The Coal
Authority

Re: Application 2024/44/92228/E

Discharge of details reserved by conditions 4 (site investigations), 6 (Phase I Desk Study Report), 7 (groundworks), 8 (Phase II Intrusive Site Investigation Report), 14 (drainage) on previous permission for 2023/93630 for erection of detached 2 storey building to form 3 retail units on the ground floor with shisha lounge above at Batley Shopping Centre, Alfreds Way, Batley, WF17 5DR

FIGURE 4 - GROUTING PLAN

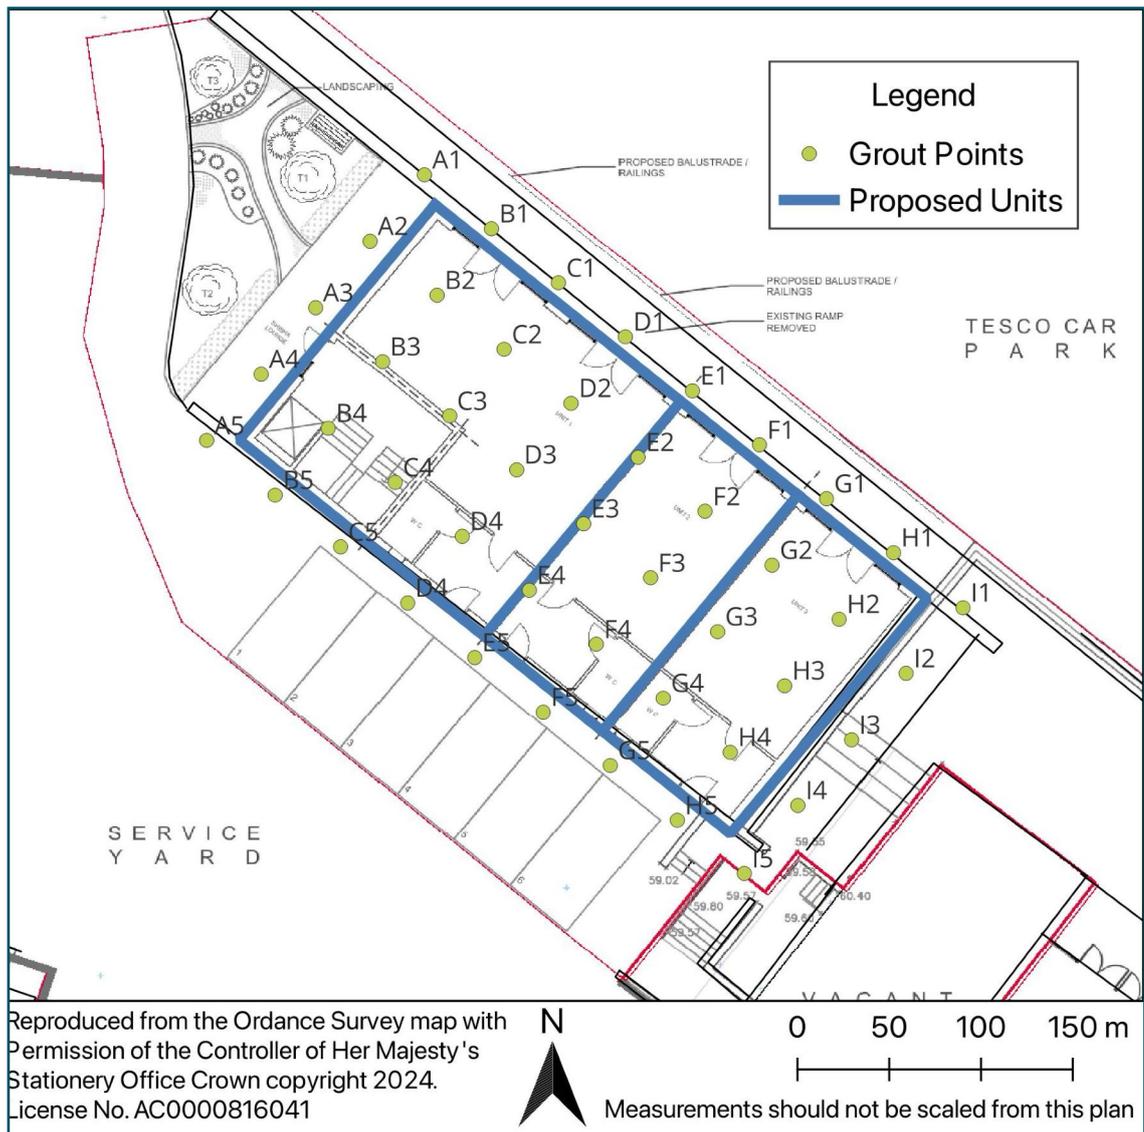
The report indicates that an intrusive investigation, comprising the drilling of two rotary openhole boreholes to depths of 30.0m bgl, was carried out at the site in order to establish the shallow coal mining situation. It advises that evidence of a worked coal seam was encountered at shallow depth. Due to the depth and thickness of the workings, the report goes on to detail a proposed drilling and grouting exercise to be carried out on a grid pattern across the footprint of the proposed building in order to stabilise/consolidate any workings present (as per report Figure 4).

The Coal Authority's Planning & Development Team welcomes the investigatory works carried out and the applicant's apparent intention to undertake drilling and grouting works to stabilise the shallow workings. However, as these remedial works have not been carried out (as required by part b) of the condition, we are unable to recommend that the LPA should discharge Condition 4 of the issued consent at this time.
